Rezoning Transportation Analysis

Petition Number: 2020-141

General Location Identifier: Tax ID 12708701

Revision Log:

**RZ-100**

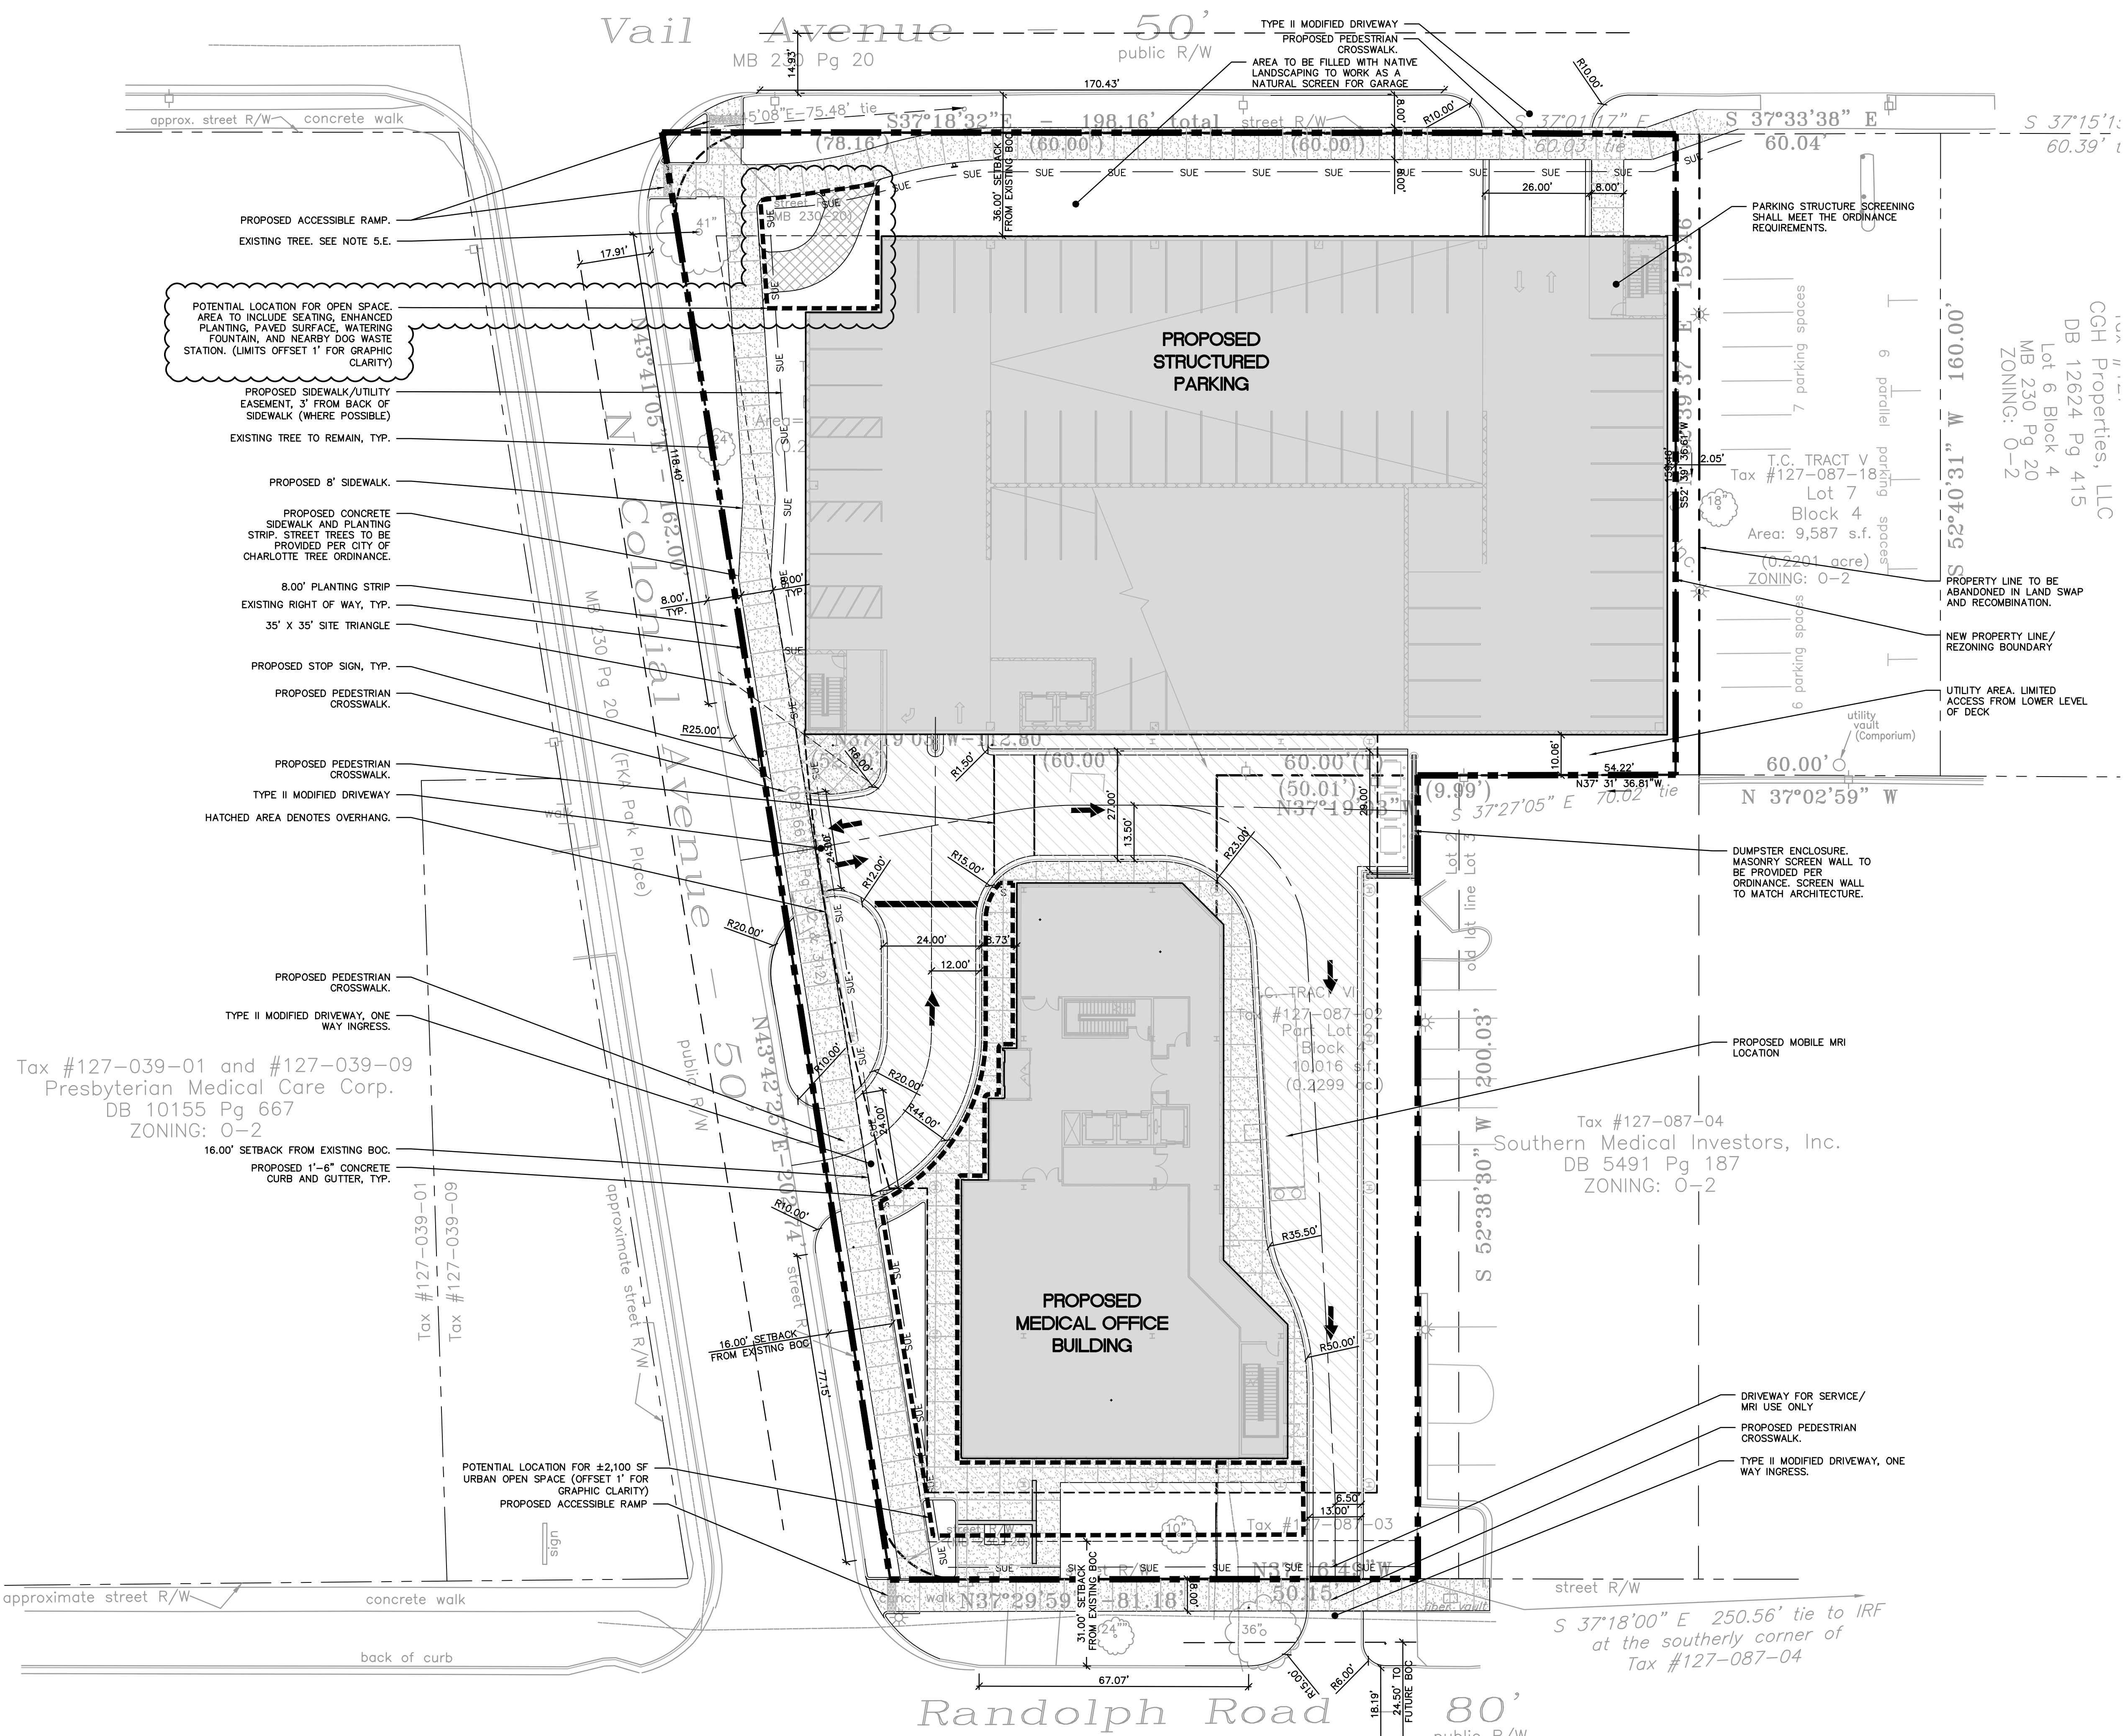
Remove Note 2 and any reference to the construction of a pedestrian refuge at Caswell and Vail per approved TIS.

Revise site plan and conditional note(s) to commit to providing traffic calming measures on Vail OR commit to providing a contribution of \$15,000 toward pedestrian program per approved TIS.
